**Subject:** FAO Adam Birkett: Consultation on planning application 3/2016/0659 The Eaves, Pendleton Road, Wiswell BB7 9BZ

**Consultation on planning application 3/2016/0659 The Eaves, Pendleton Road, Wiswell BB7 9BZ**

Wiswell Parish Council has considered this application and is concerned that planning consent for tree removal is open to interpretation and needs to be clarified.

drawing stage	PLANNING		
drawing status	APPROVAL		
client	NEW HALL WISWELL		
project	NEW HALL PENDLETON ROAD WISWELL		
drawing title	APPROVED ELEVATIONS EAST (ROAD SECTION)		
date	20/06/16	drawn	JR
scale	1:200 @ A3	checked	FS

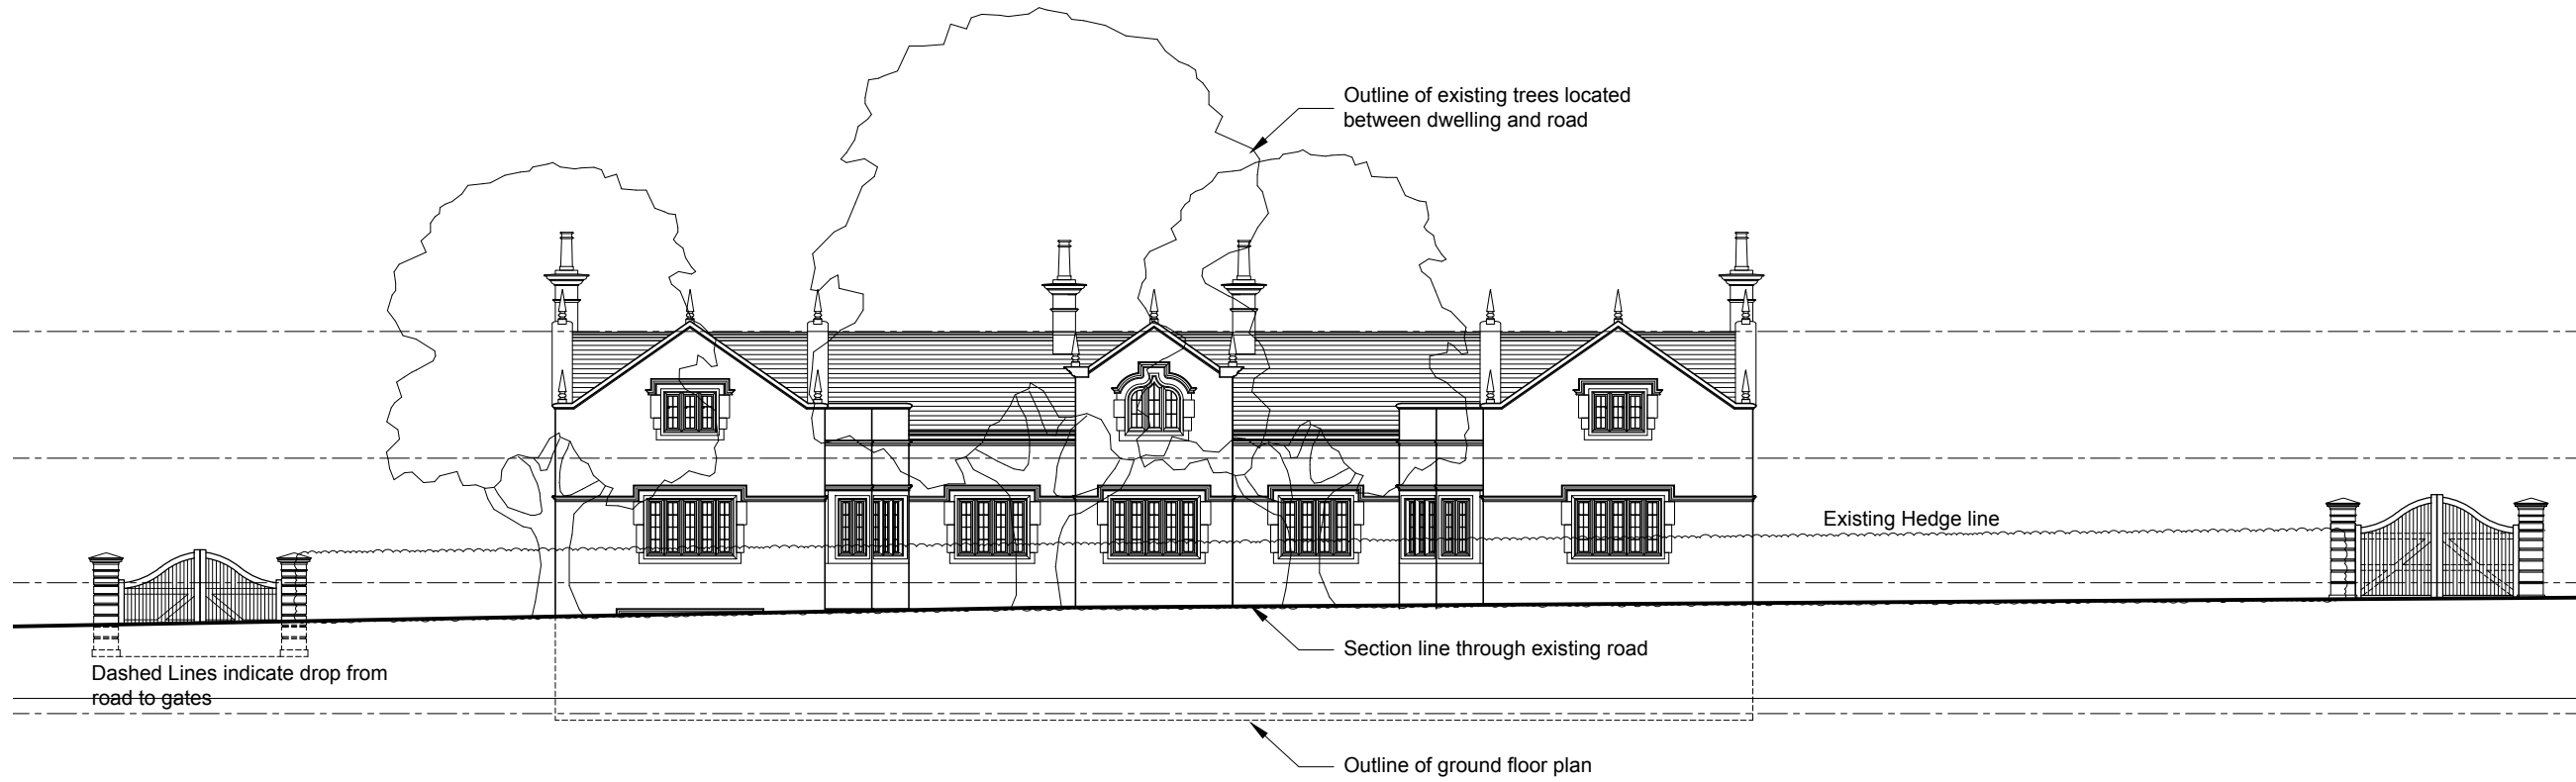
1. The proposed site plan includes trees which have already been removed during the construction of the house although planning conditions for landscaping have not yet been discharged.
2. The proposed site plan refers to land which will be maintained by grazing animals but this land has been landscaped.
3. The proposed site plan does not include reference to tree T02 that is planned for removal.
4. The proposed East elevation shows an image with no trees facing Pendleton Road. Are there plans to remove further trees than tree T02?
5. There are no plans for the North and South elevations on RVBC website. The east elevations are shown twice.
